From: Zac Denton <Zac.Denton@arun.gov.uk>
Sent: 04 January 2021 09:22
To: Planning.Responses <Planning.Responses@arun.gov.uk>
Subject: FW: Urgent - Case reference: AB/109/20/HH

Re:- 32 King Street Arundel - Job 20524 Planning Reference AB/109/20/HH

Regarding the proposed extension at number 32 King Street; please note that the proposed works will require a Party Wall Award with particular consideration to the boundary wall and number 36 King Streets property. It is my understanding that the works entail lowering the ground on number 32 King Street by a minimum of 500 mm against a historic listed structure. The Structure is constructed out of weak and poor bungeroosh/flint and any consideration to the works taking place must include an assessment of this material along with sequenced temporary works.

PROPOSED GROUND FLOOR PLAN

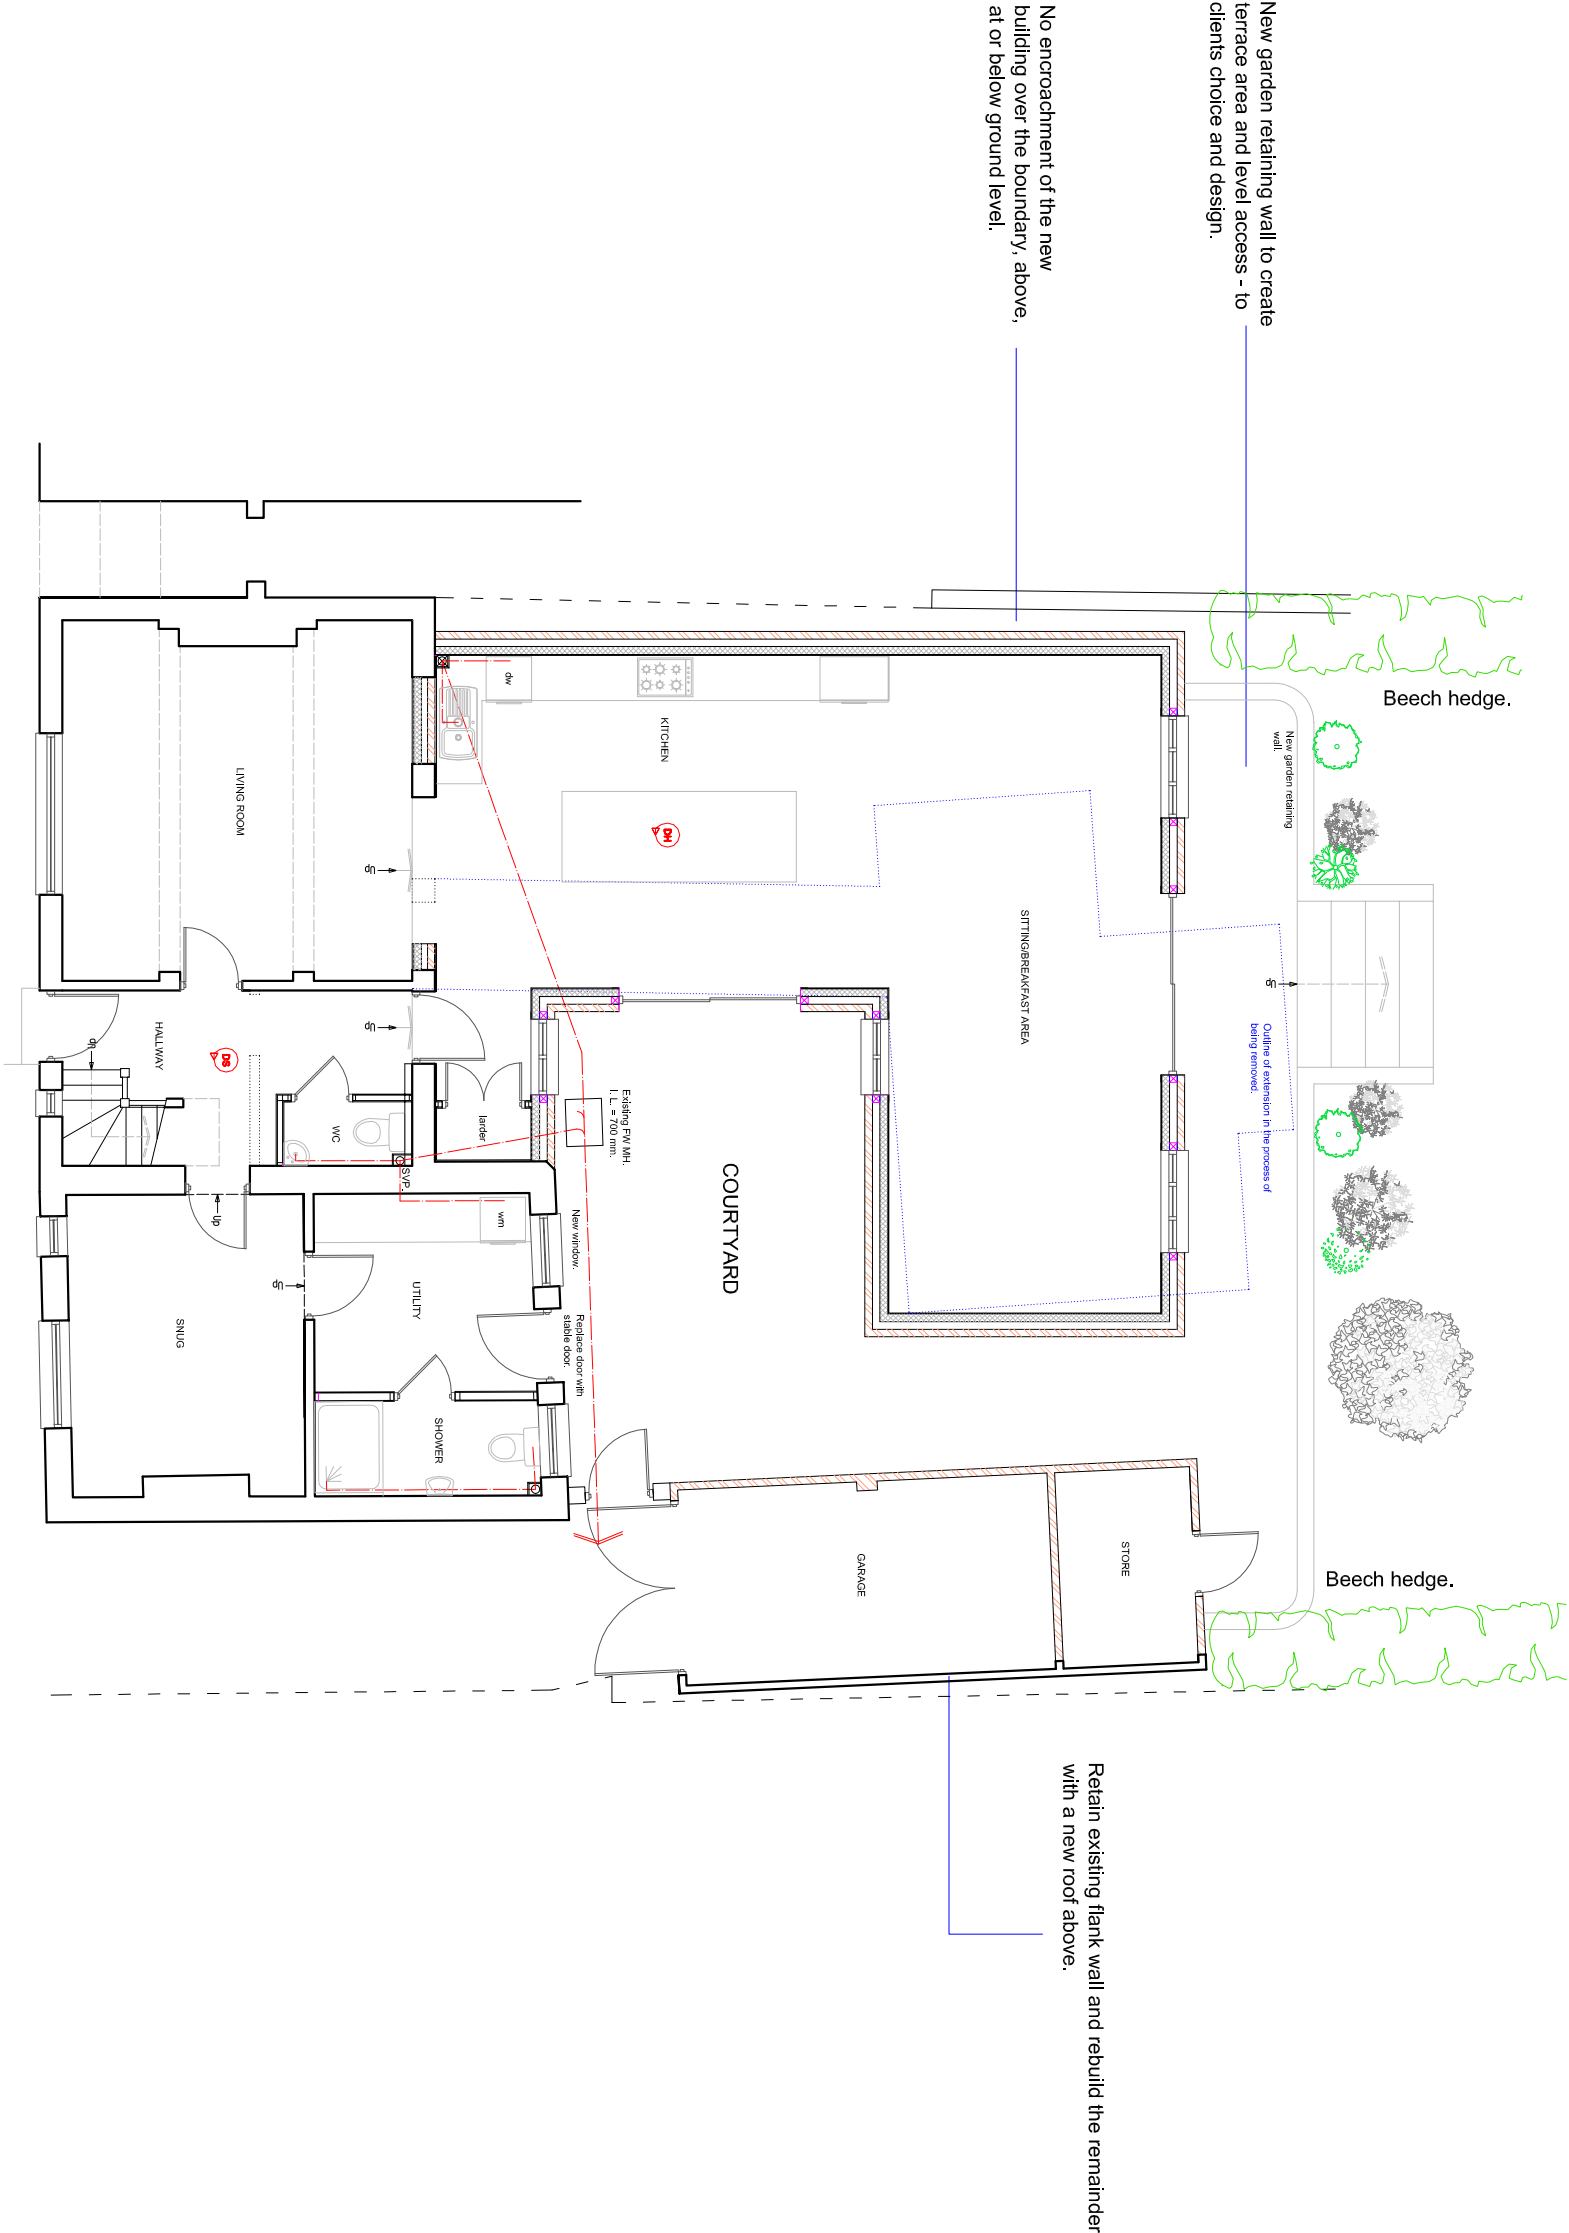
Regarding the proposed extension it is likely that a reinforced concrete retaining wall will have to be constructed in sequenced bays of no more than 900 mm long bays. Only a maximum of 25% of the length of the wall can be underpinned in any one go. Propping and shoring of the Party Wall will also have to be designed and set out on plan along with sections.

Prior to works commencing a full drainage survey will also have to be carried out to ascertain the existing network and condition along with proposed new drainage located on plan.

The proposed design will have to consider all geological, hydrological and structural concerns with sequences shown on plan along with a method statement for the works. The retaining wall design will have to consider all these factors.

Please note we would also recommend that movement monitoring is included as part of the Award.

Although the above is not impossible to design and implement; We would want to review all proposed works prior to any construction taking place. Structurally the proposal of lowering the extension in our opinion does pose a high risk to the existing Party Wall.
